## Department of Transportation

December 4, 2019

RE: Pearson's Ministries - dba Legacy Church - Site Development Plan\_PPR1933

C2.1

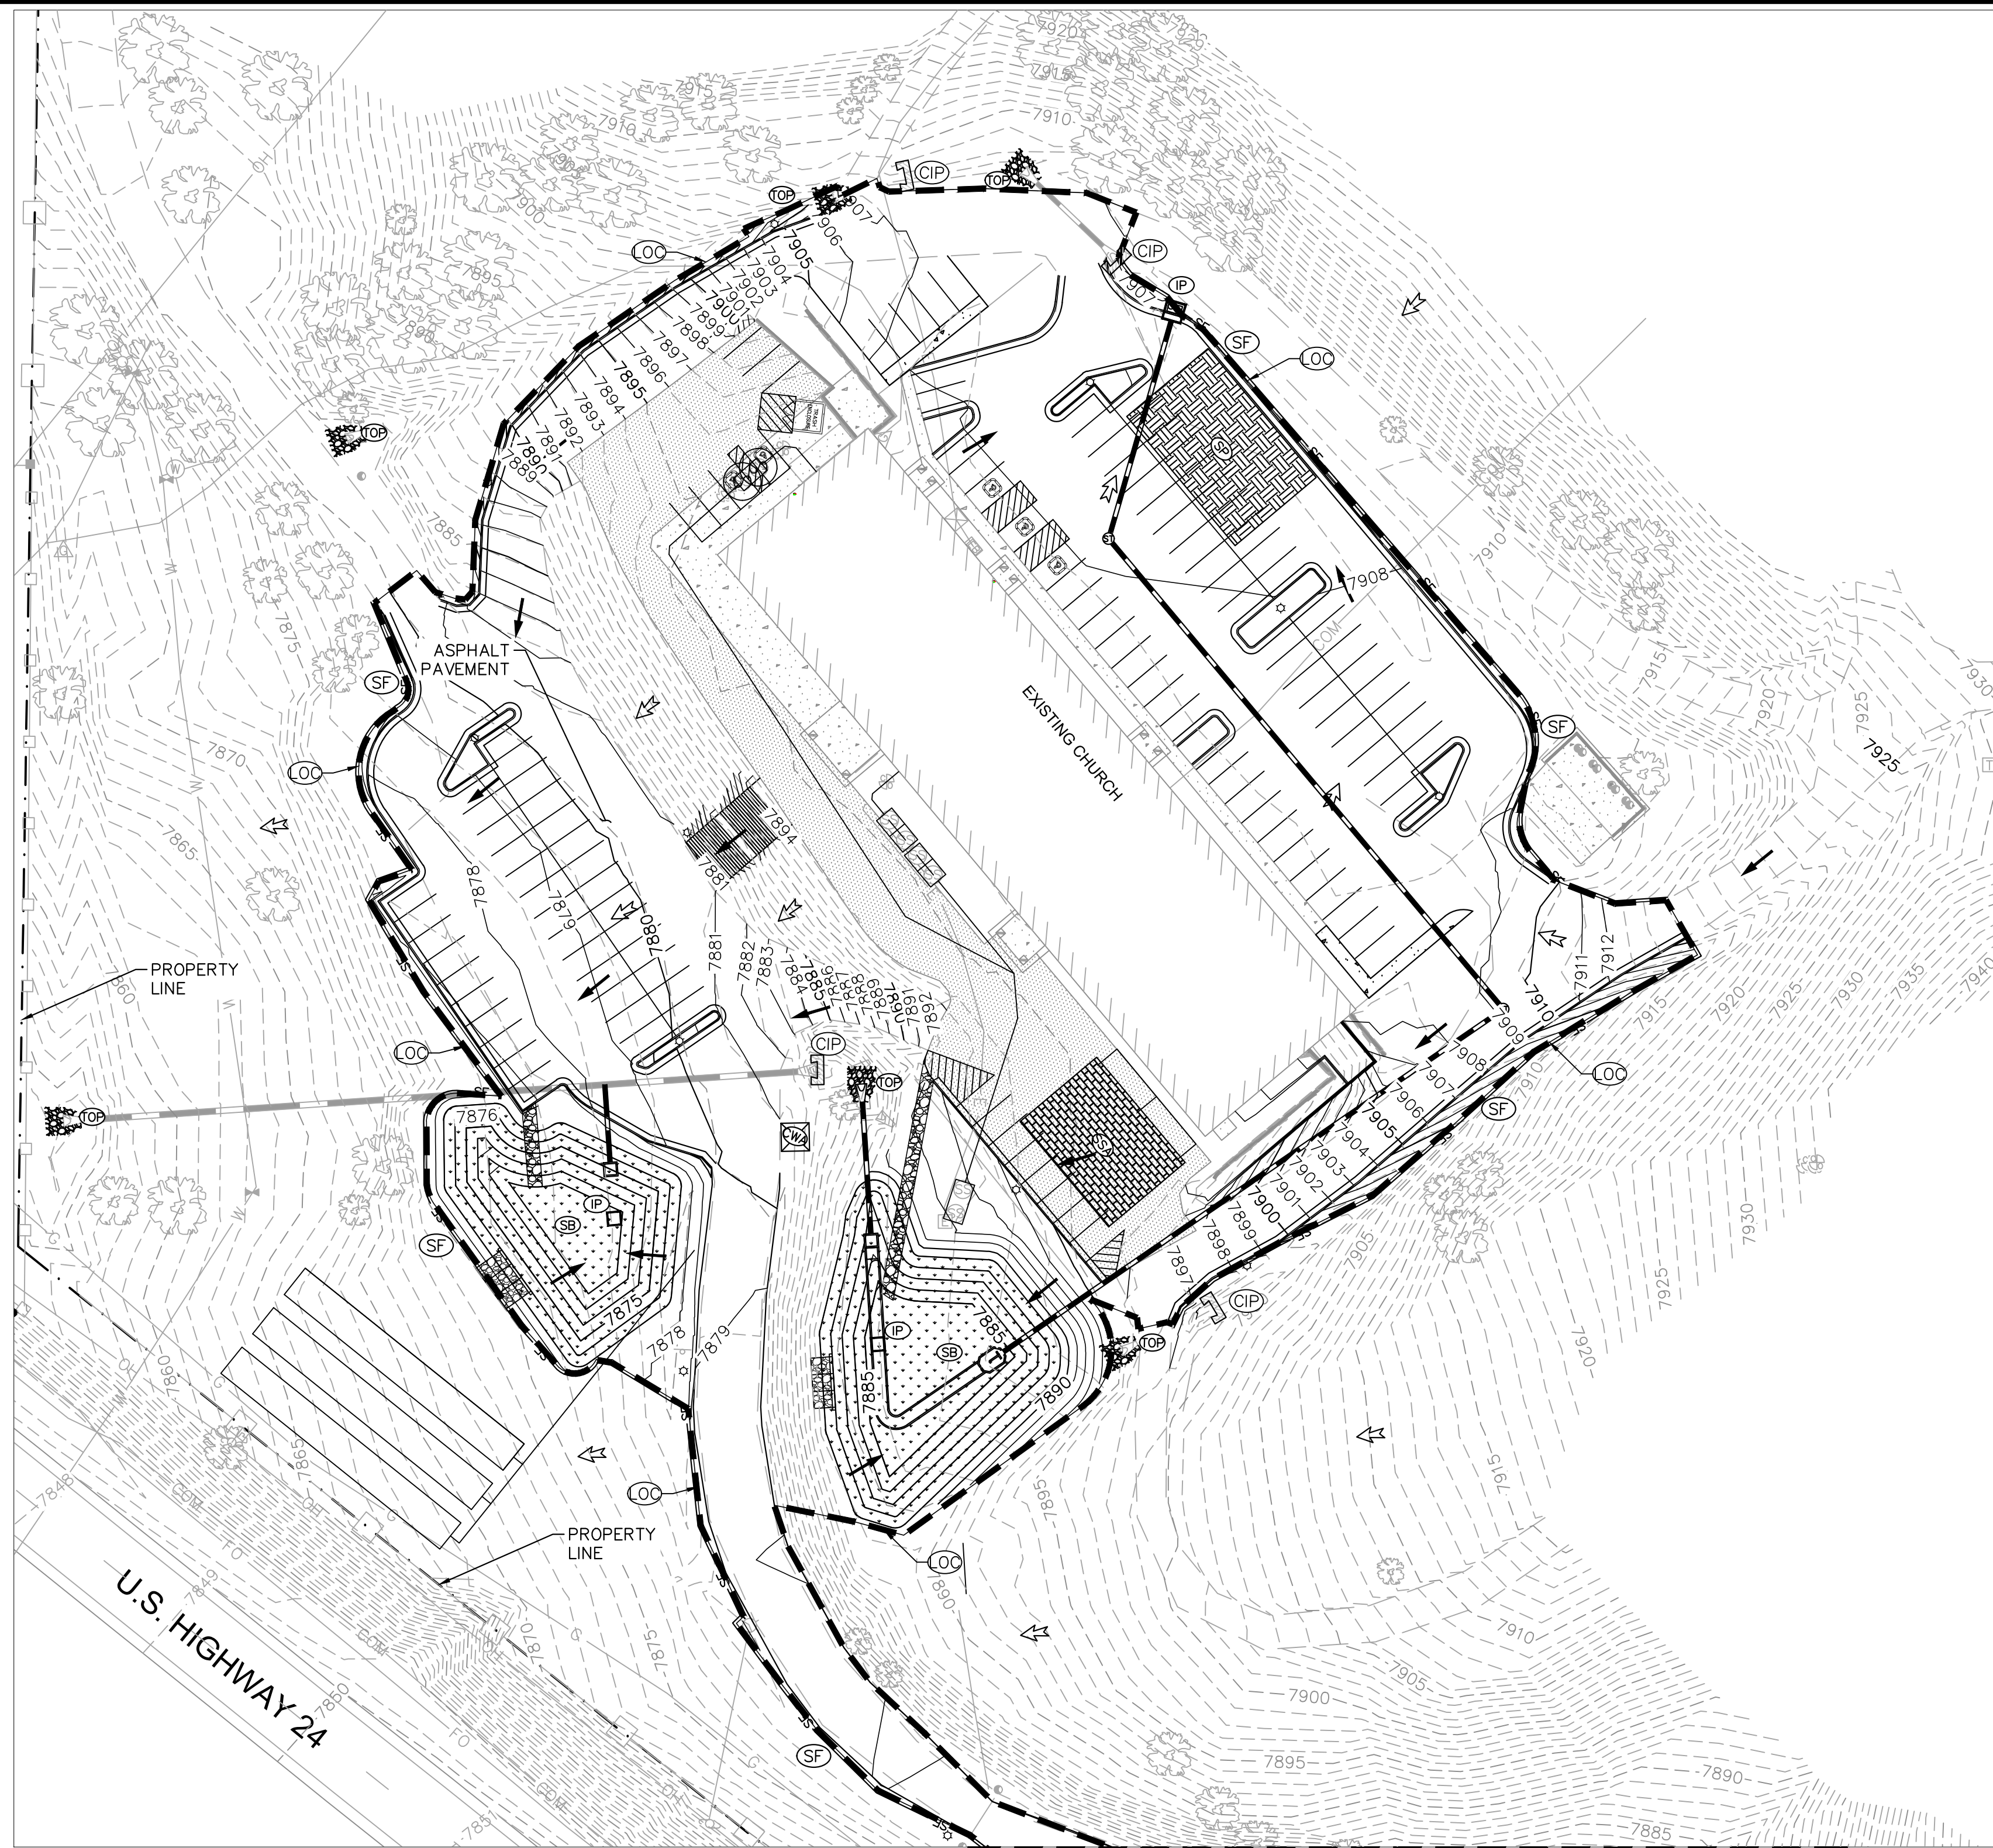
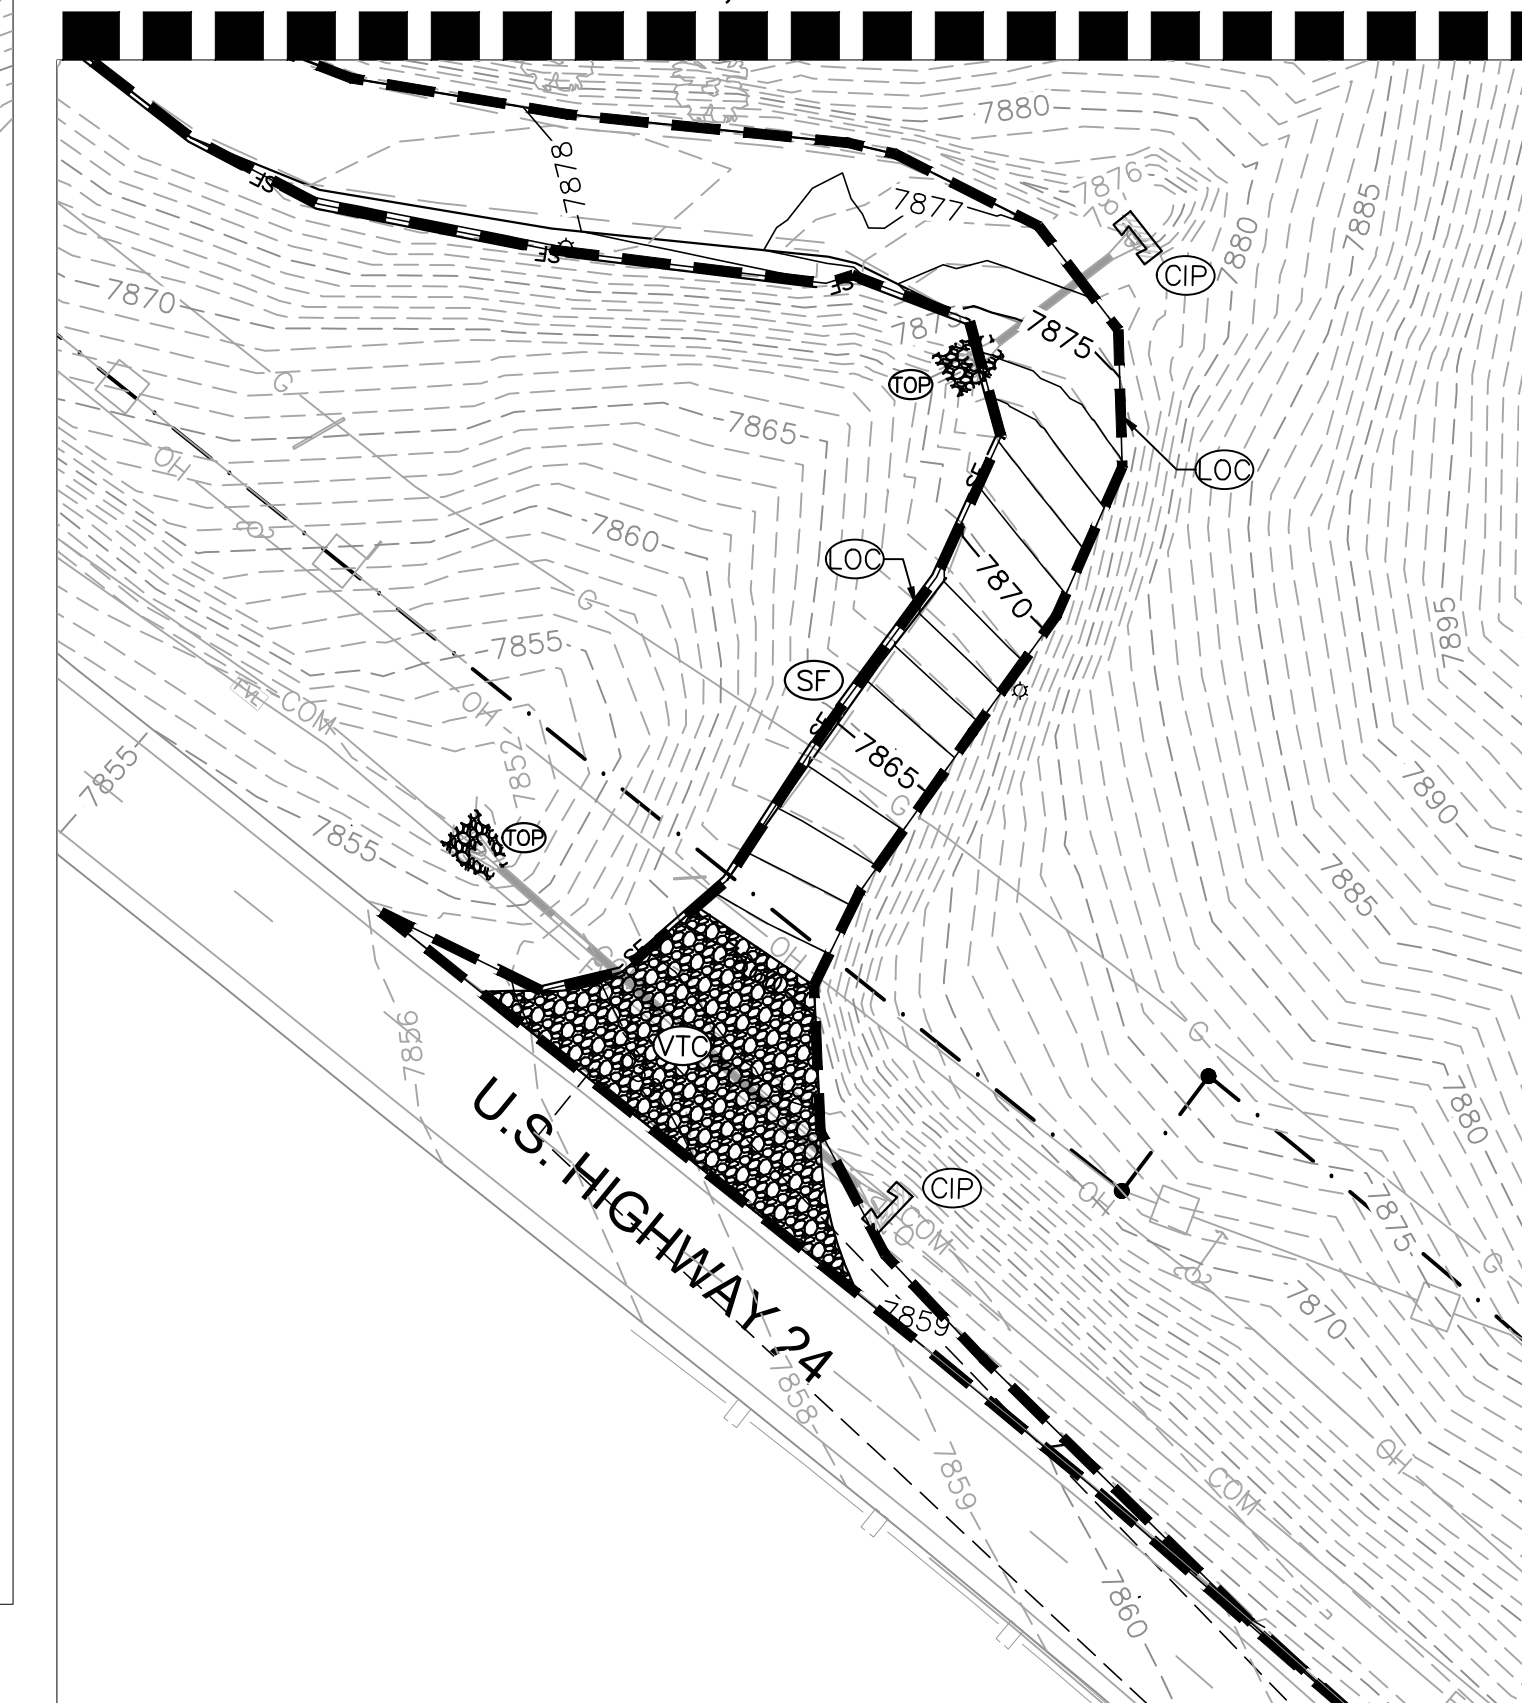
- e. Need plans for construction site BMPs so that CDOT ROW isn't inundated with sediment from the construction project site. Significant grading on the project has high potential of erosion.

REV: 11/22/19
REV: 10/18/19
PROPOSED DRAINAGE PLAN
SHEET 2 OF 3

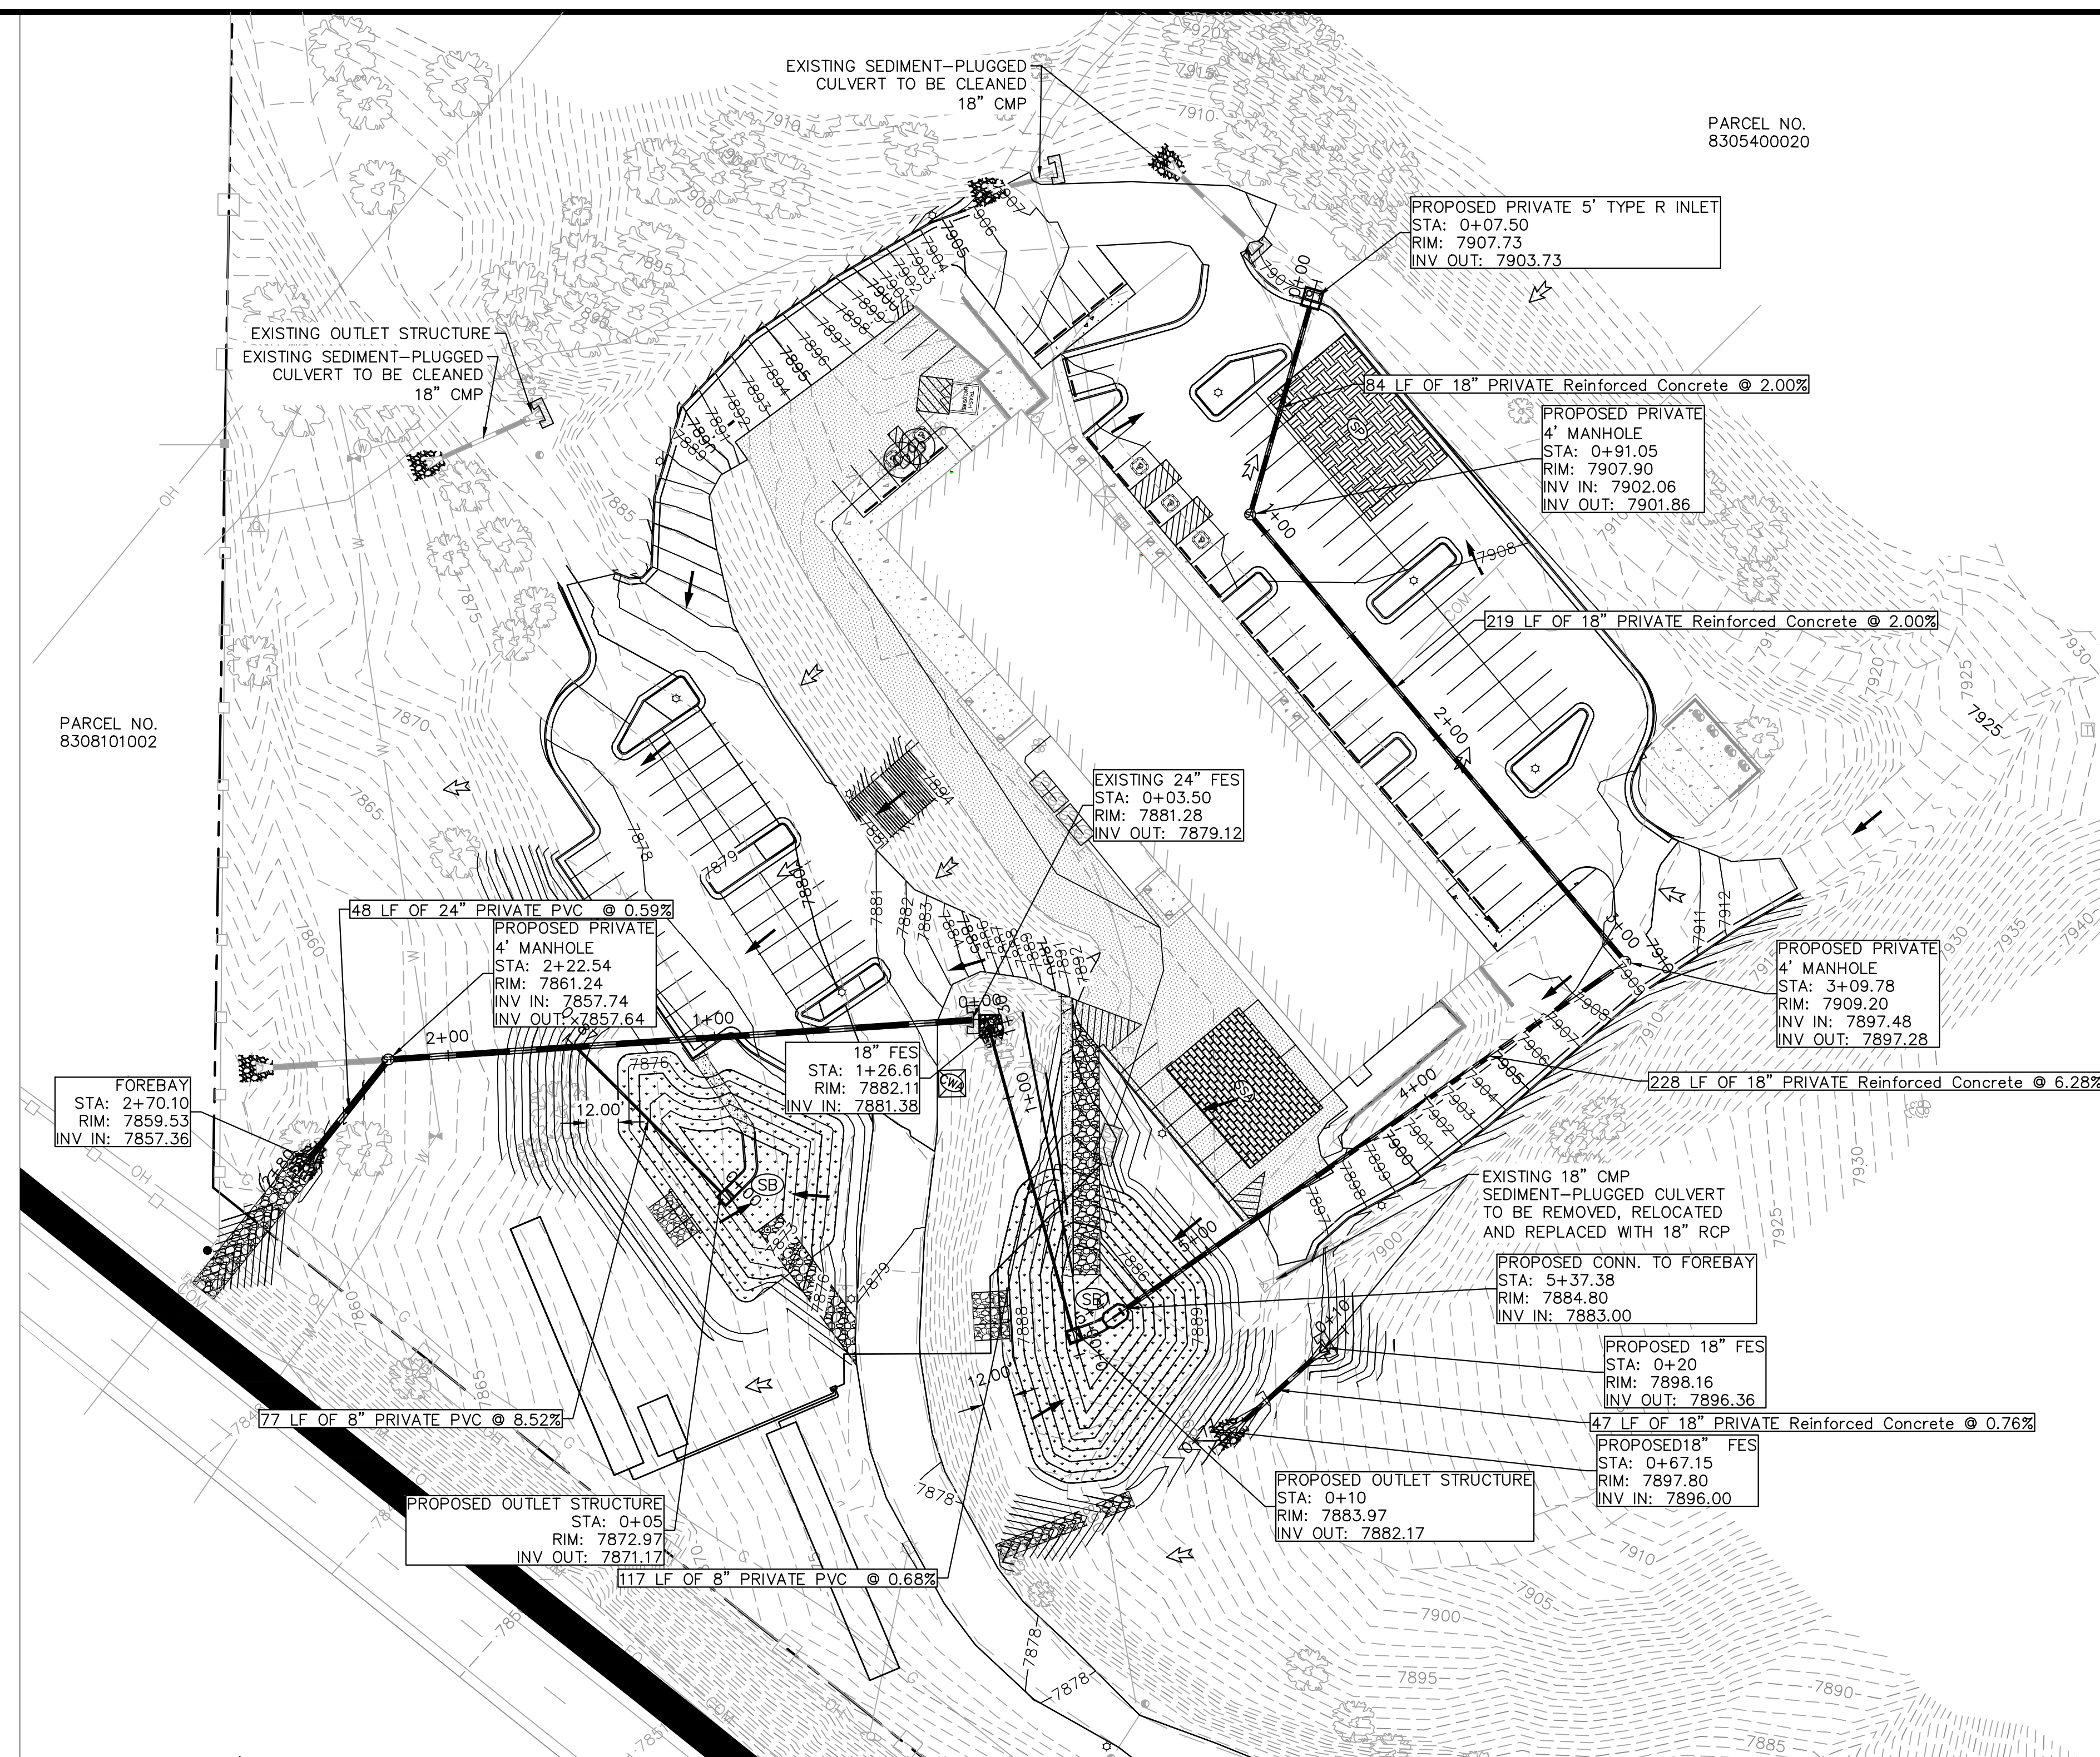
- c. Existing 24" pipe draining to the southwest is shown connecting to a pipe that appears to be proposed by this project, sheet 4. Details are missing, please provide.

- d. Riprap rundown shown at the outlet of the proposed pipe run CO1. Need to see construction details and calcs that show the proposed riprap design is adequate. Drainage report mentions that this is a concrete rundown. Which is it? Need to ensure that it extends to the bottom of the CDOT ditch and up the ditch backslope to ensure the ditch is not eroded.

- f. Grading of ponds need to be refined. Specifically, it looks like the grading of the western pond doesn't tie to existing properly.
- g. Looks like there may be a conflict with the proposed septic system and the proposed detention pond and drainage system. Please confirm. The septic system and drainage system are not shown on each other's plans, so there is no way of knowing if there is a conflict.
